Steelworks Cogeneration Plant Project  
BlueScope Steel (AIS) Pty Ltd  
(Attention: Steve Shaw)  
PO Box 1854  
WOLLONGONG NSW 2500

**BLUESCOPE STEEL COGENERATION PLANT  
PROPOSED SALT WATER COOLING**

## Attachment A – Department of Environment and Climate Change comments on the reports submitted to date

Figure 3.1
Thermal Treatment Infrastructure

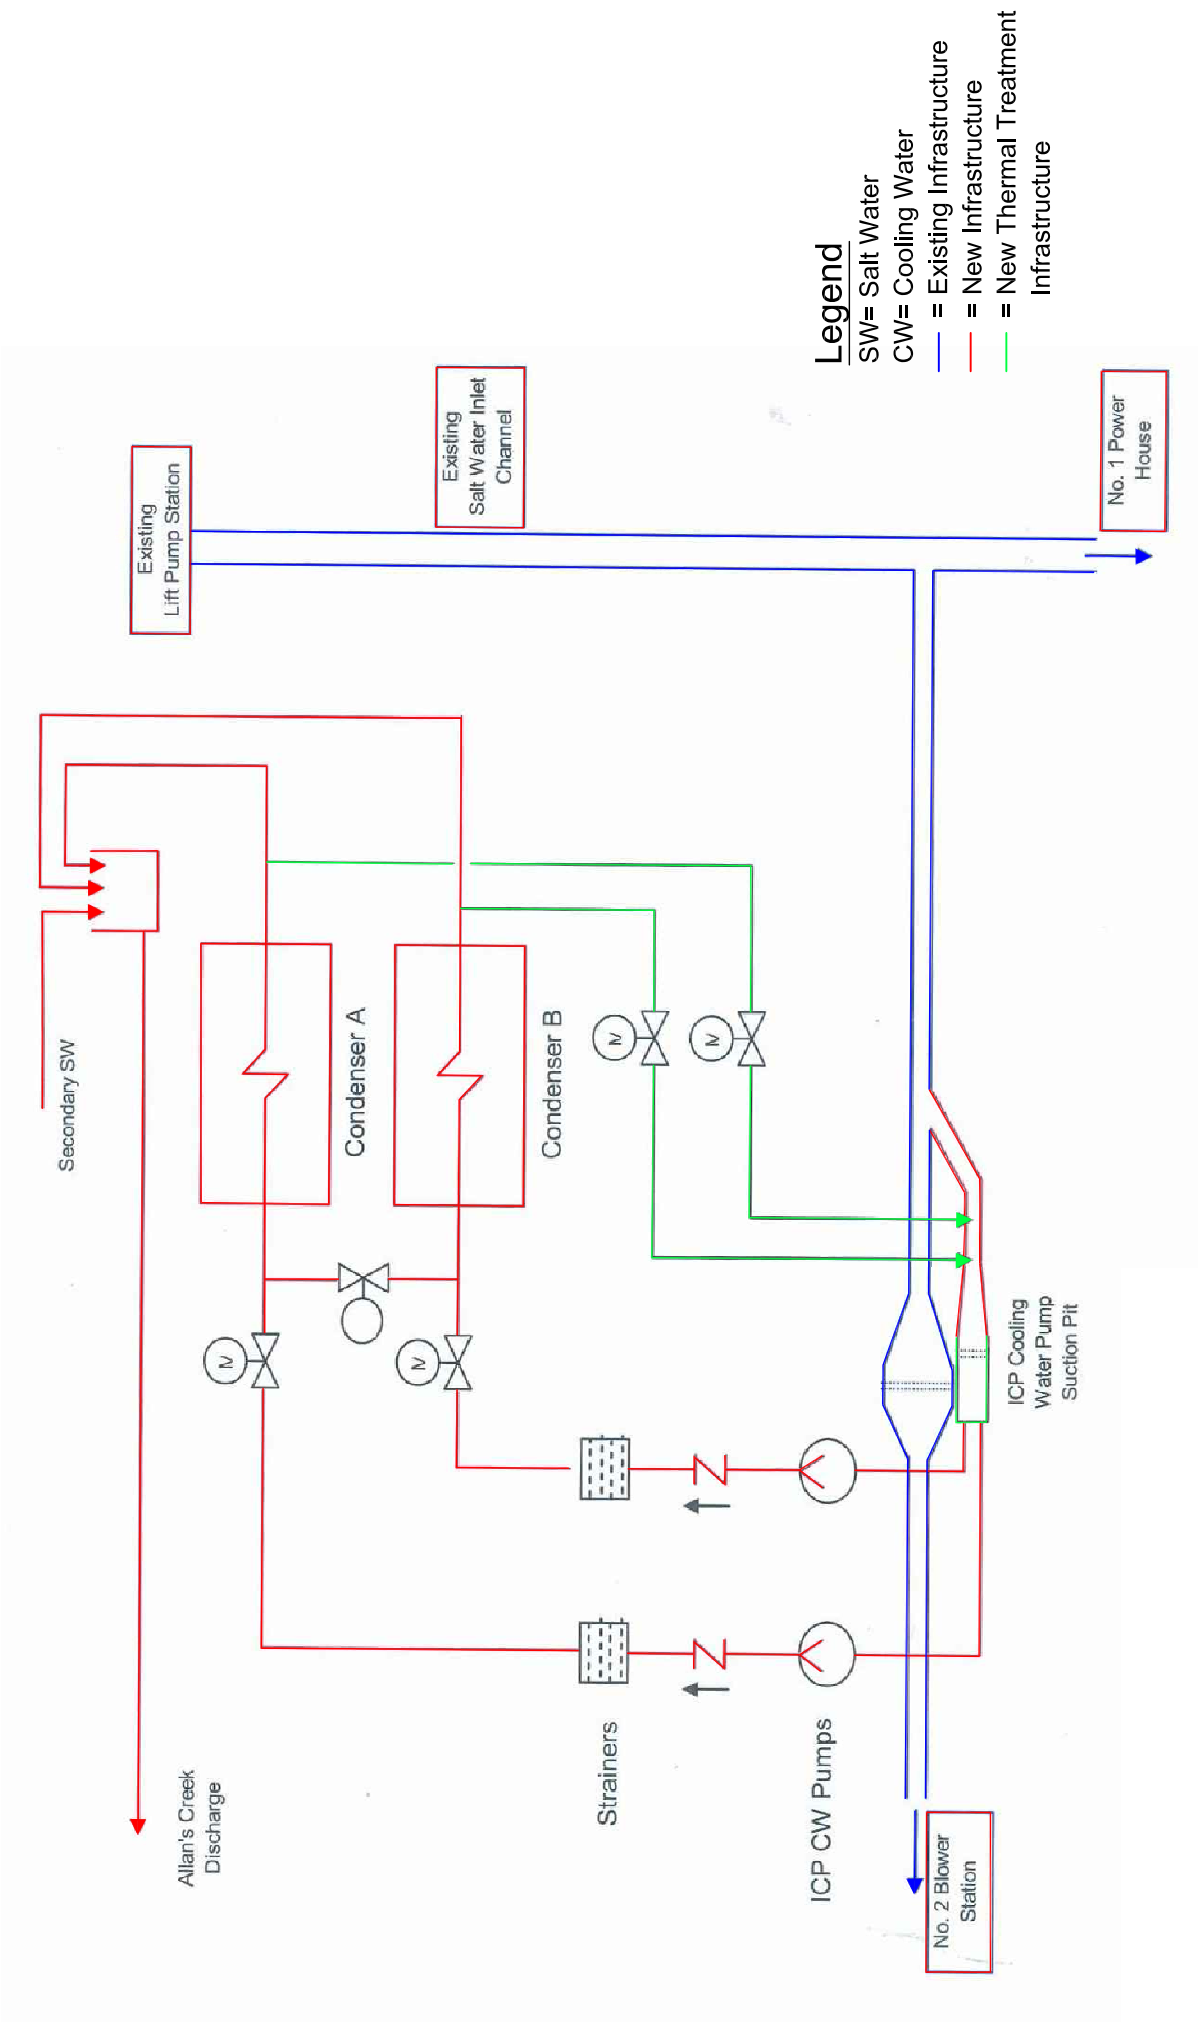
8. An assessment must be undertaken on biological controls which assesses the viability of both physical and chemical control agents. In relation to any chemical agents, an assessment must be undertaken on the ecotoxicological impacts to receiving waters including the identification of measures to minimise impacts. Justification should be documented on the preferred biological treatment option.
